CITY OF ALBUQUERQUE

February 17, 2017

RE: 7001 Signal Ave. Allergy Clinic
Grading and Drainage Plan
Engineer's Stamp Date 1-31-2017 (File: C19D065)

CITY OF ALBUQUERQUE
PUBLIC WORKS DEPARTMENT
ENGINEERING DEVELOPMENT GROUP
7001 SIGNAL AVE. N.E. - ALLERGY CLINIC
GRADING AND DRAINAGE PLAN

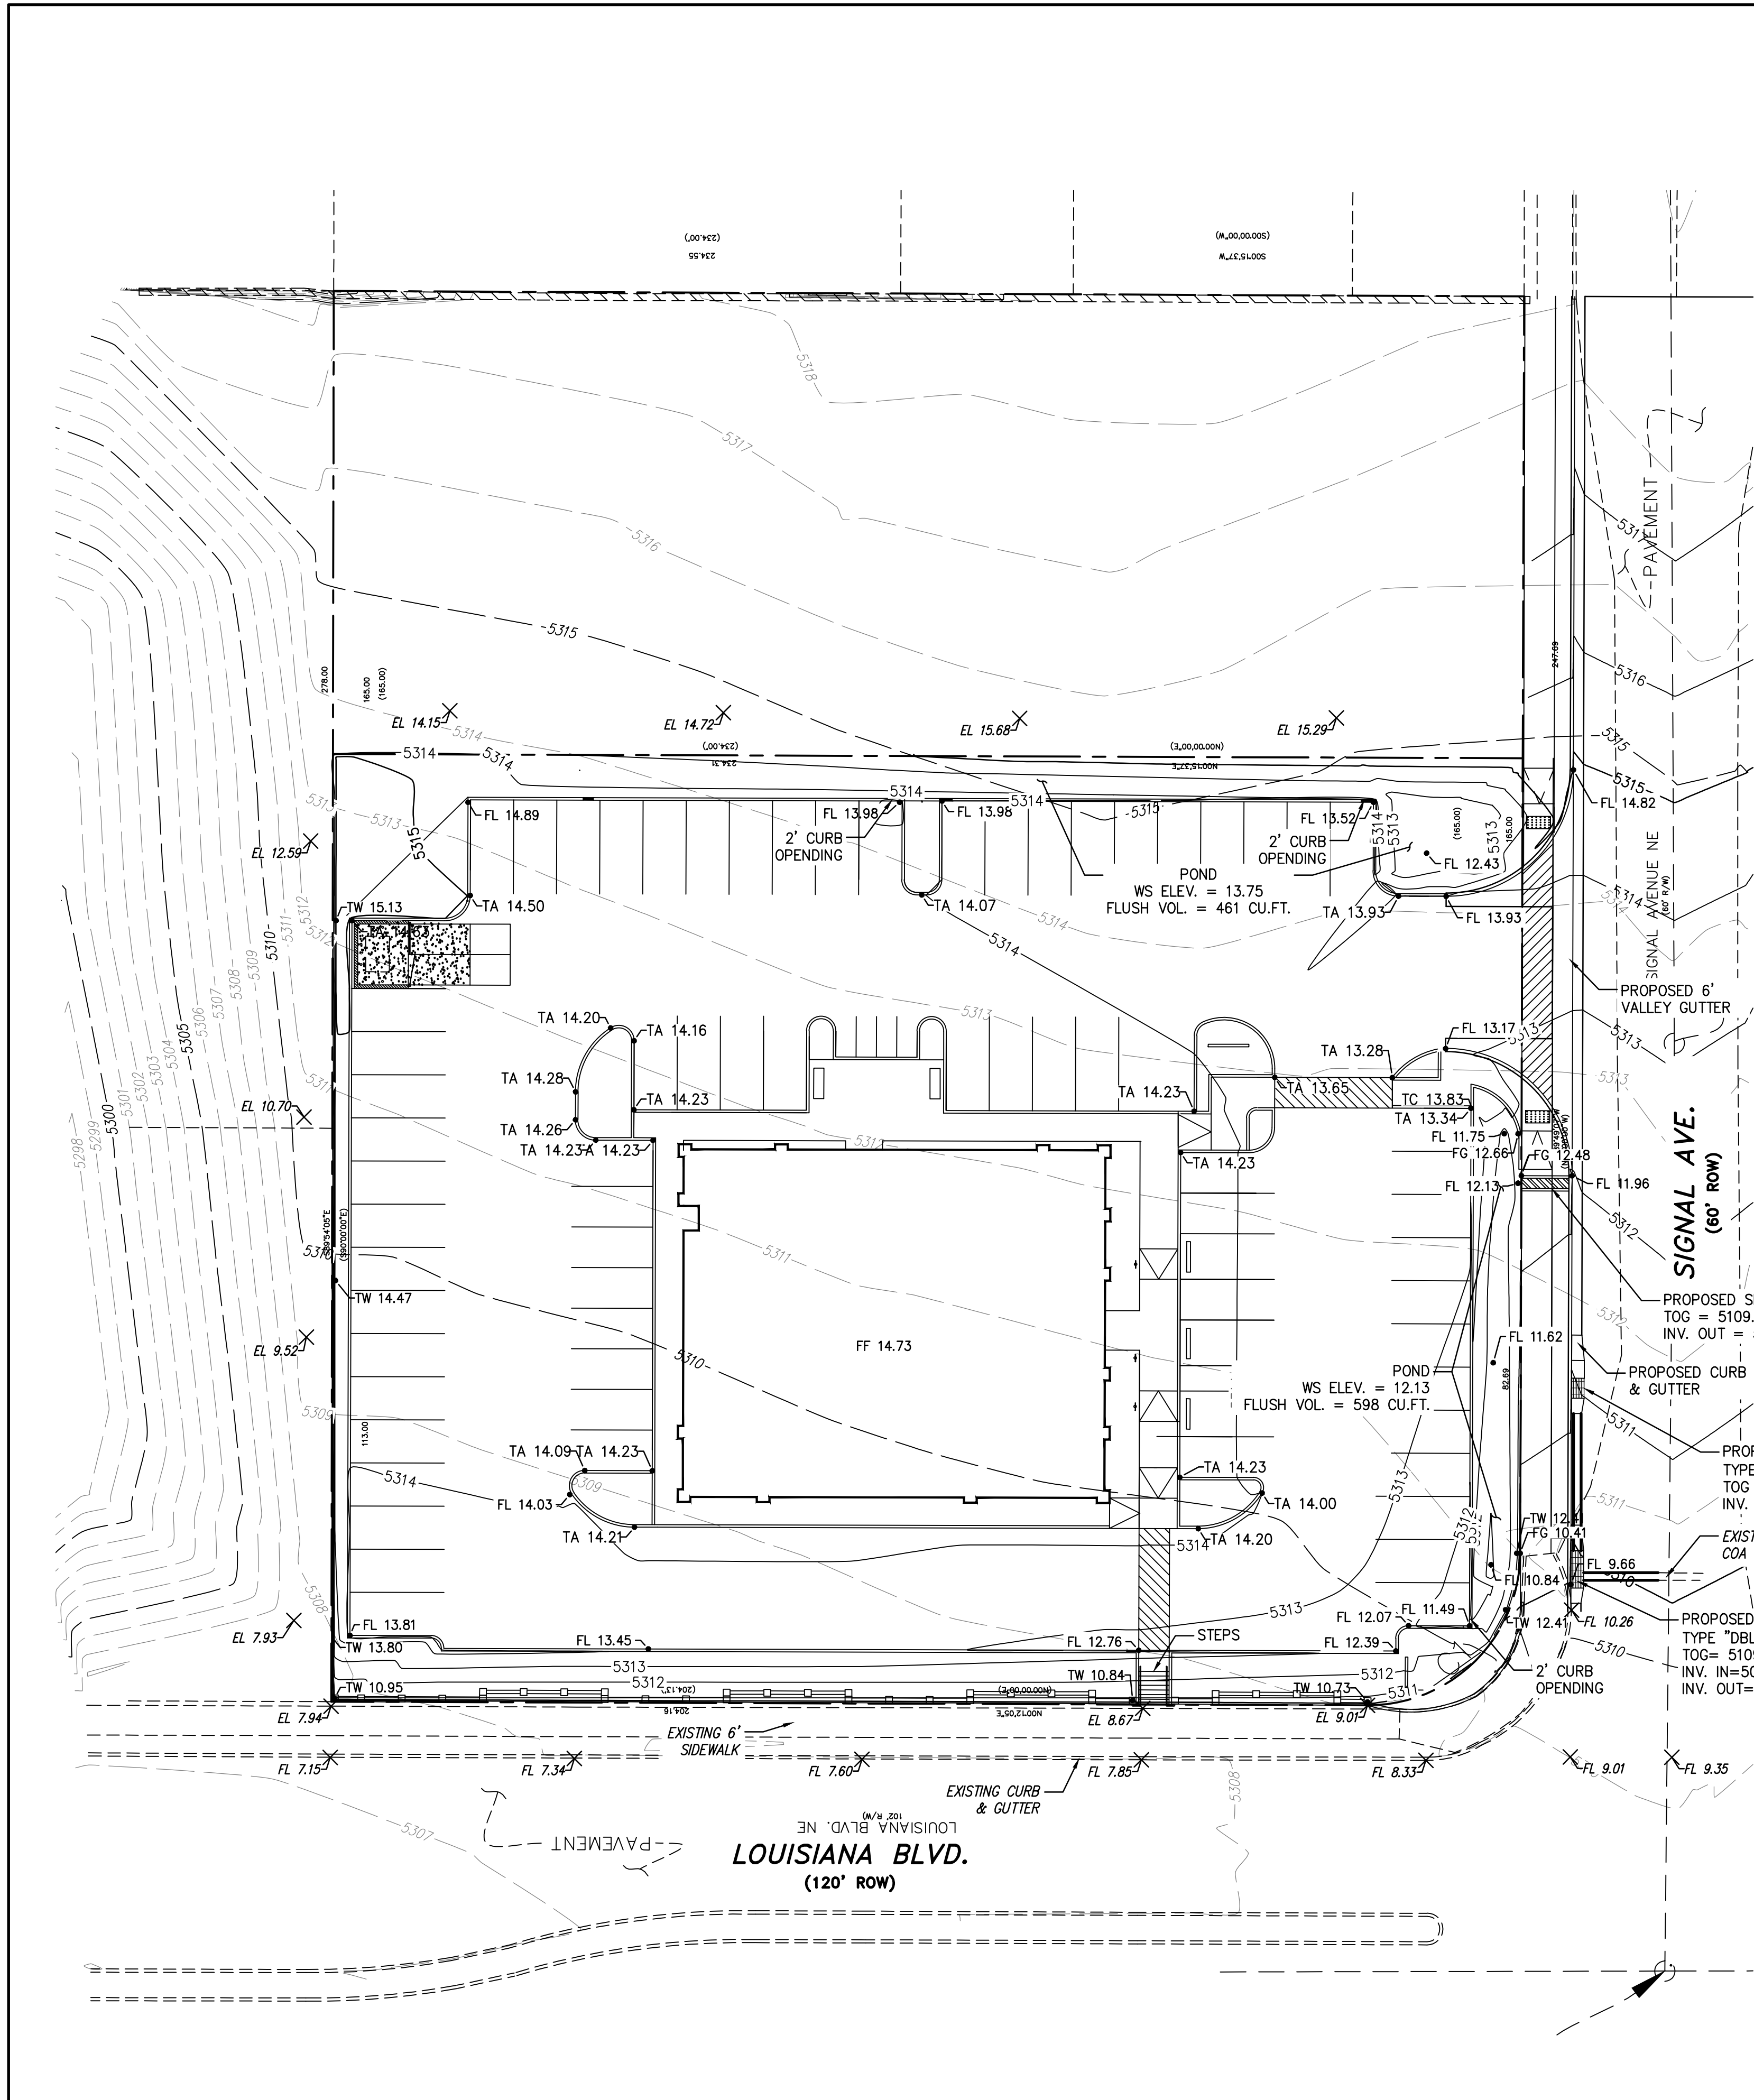
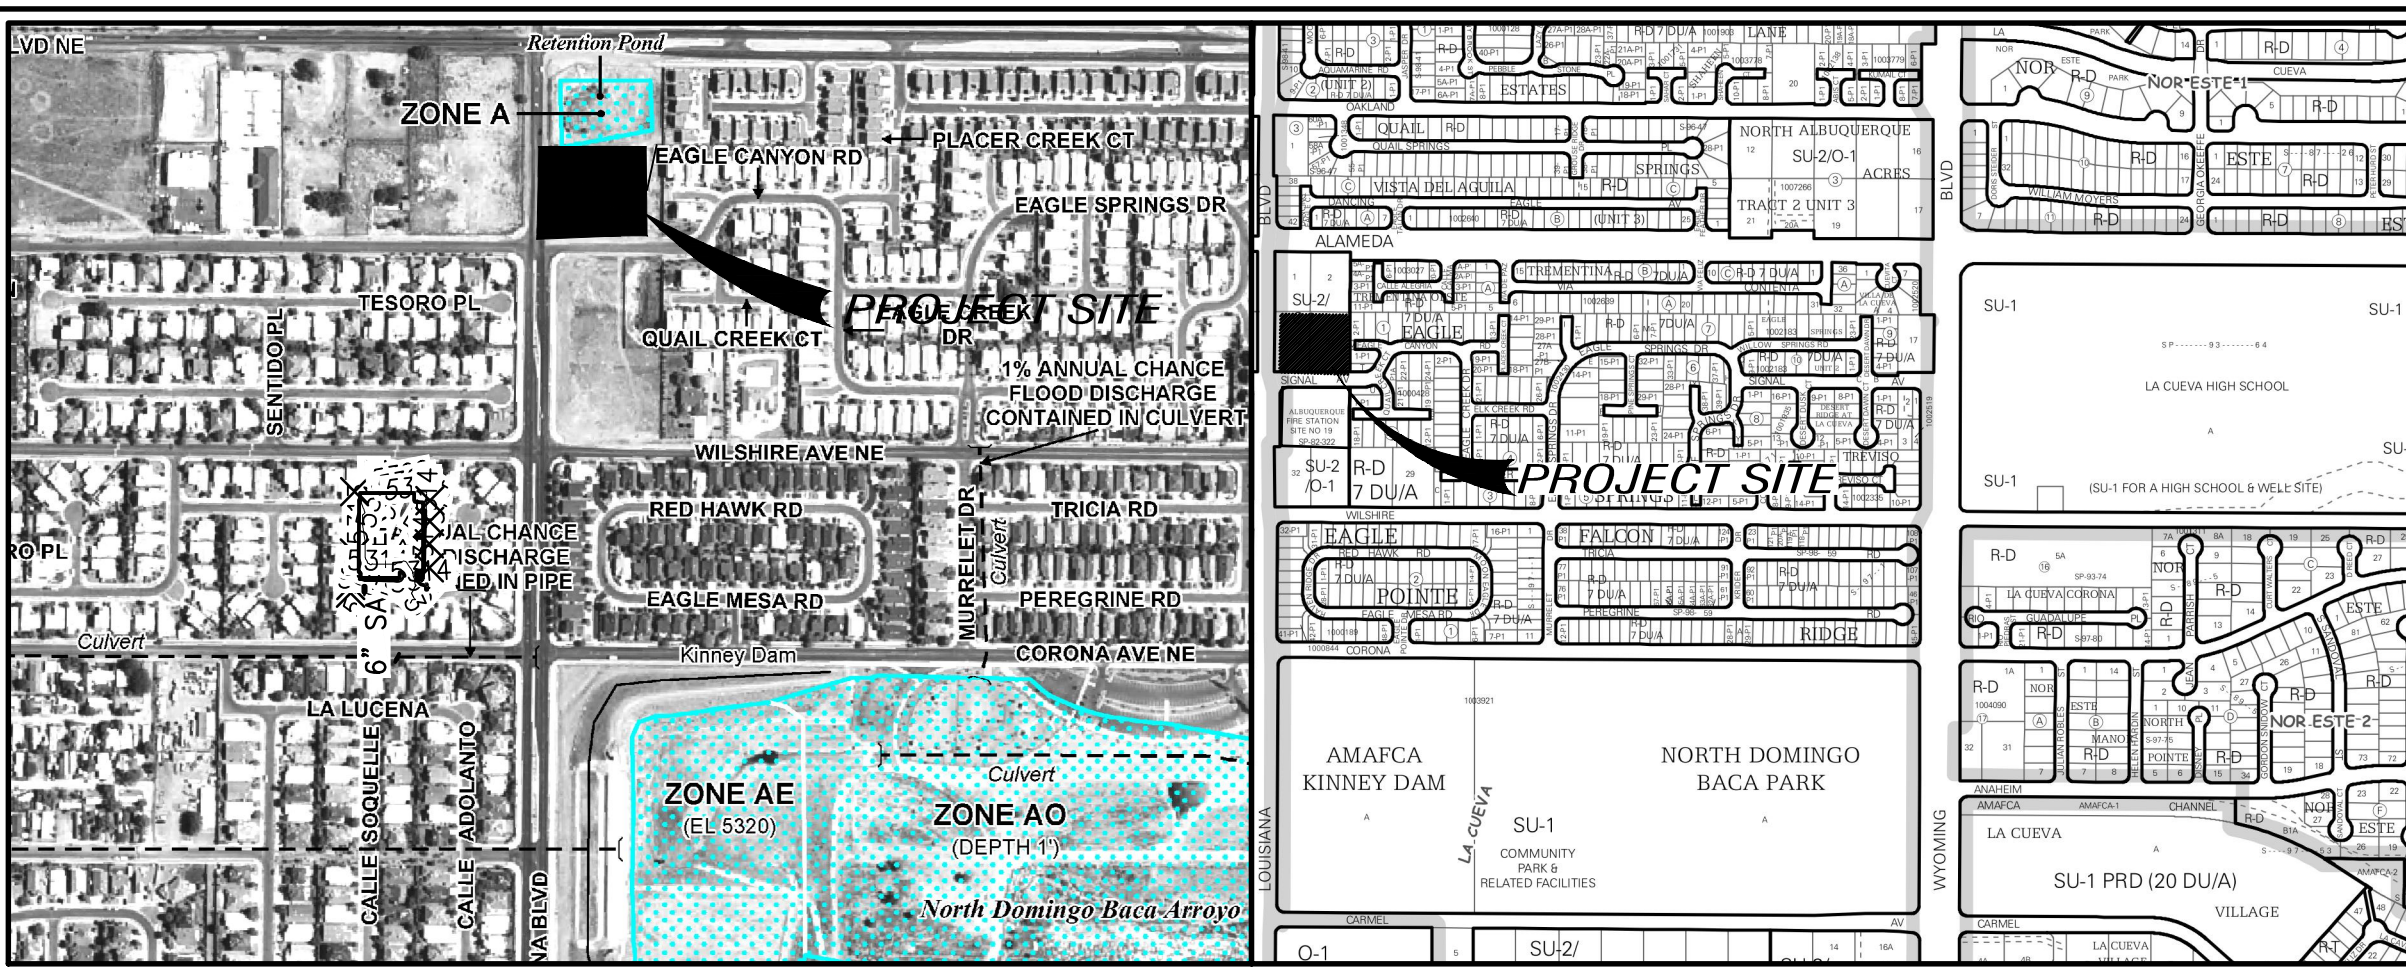
1. Extend the sidewalk culvert plus plate 12 inches passed property line.
2. Please make sure sign shown at the southwest corner of Louisiana and Signal will not create clear sight distance issues.
